07 February 2022

NSW Department of Planning, Industry and Environment
12 Darcy Street
Parramatta NSW 2150

**Building R4A SSD 6964 – MOD 5
Response to RFI – Further Plans
Barangaroo South**

R4A  
 SETOUT PLAN BASEMENT LEVEL B1

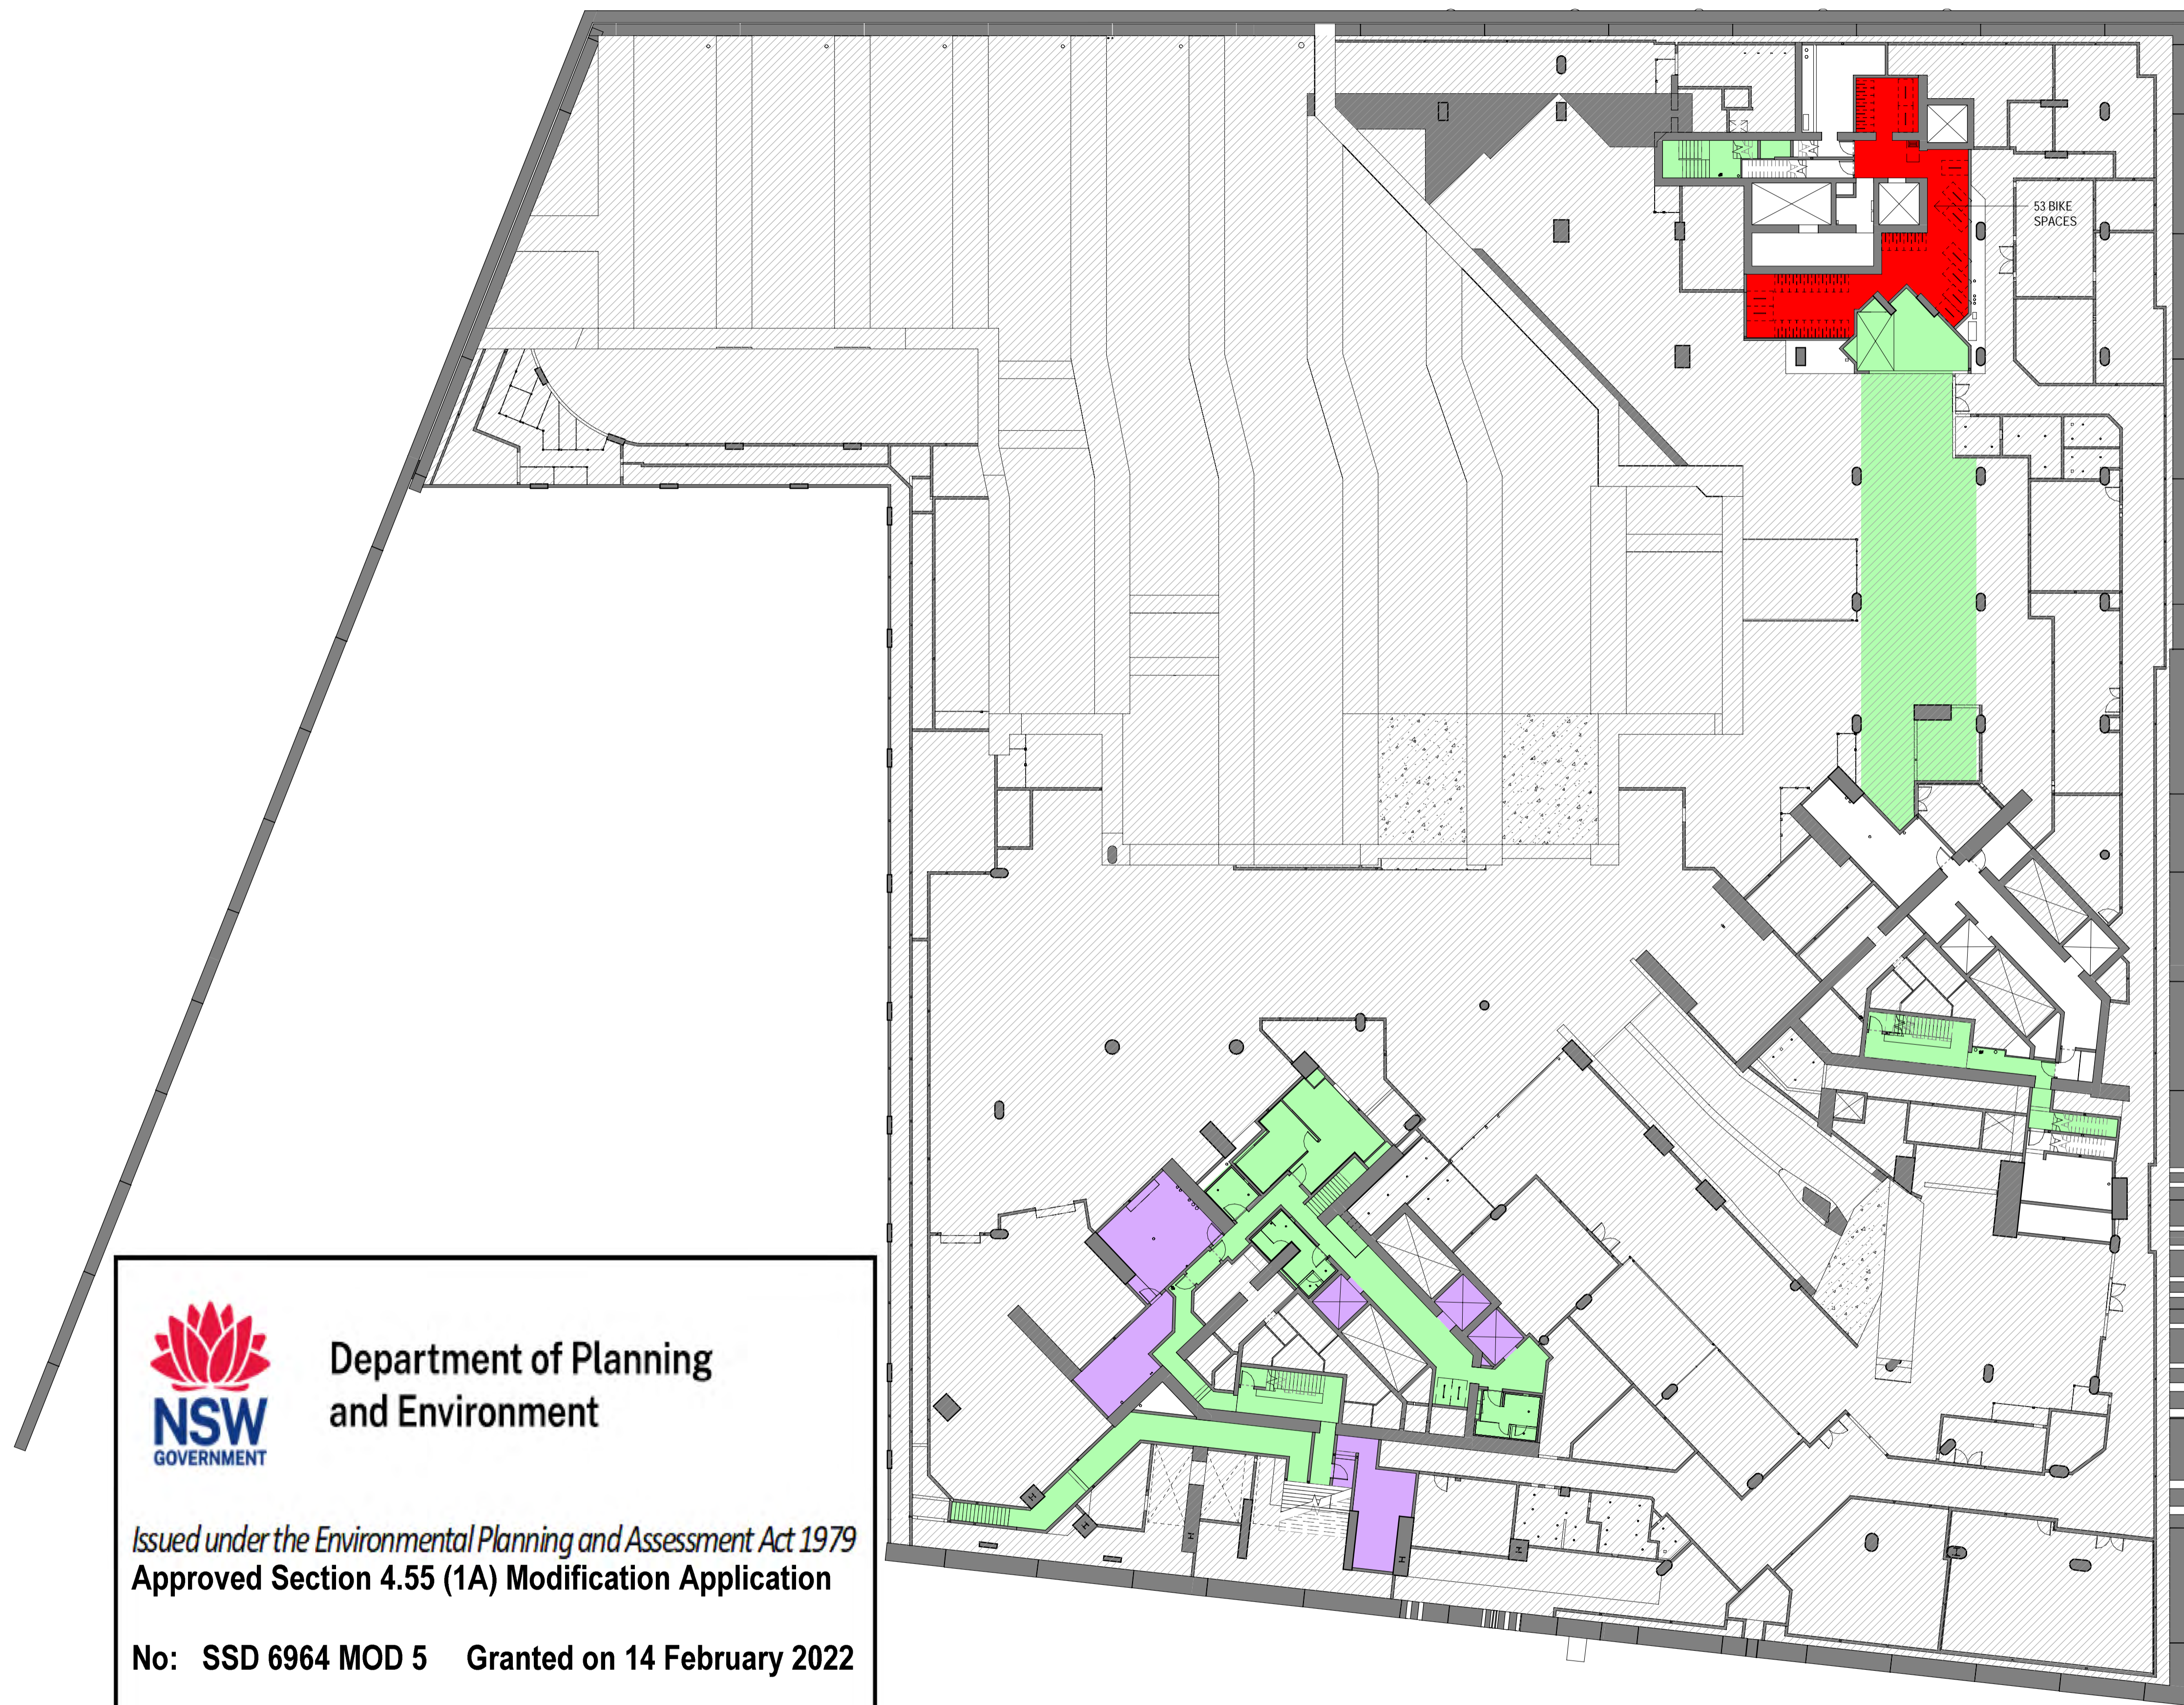
Please find **attached** Level B0 Plan. In addition, we have noticed that in the printing of plans, an area of bicycle parking on Level B1 also disappeared. See extract below.

Accordingly, we also **attach** a replacement Level B1 Plan for the Determination which corrects the bike parking – extract below.
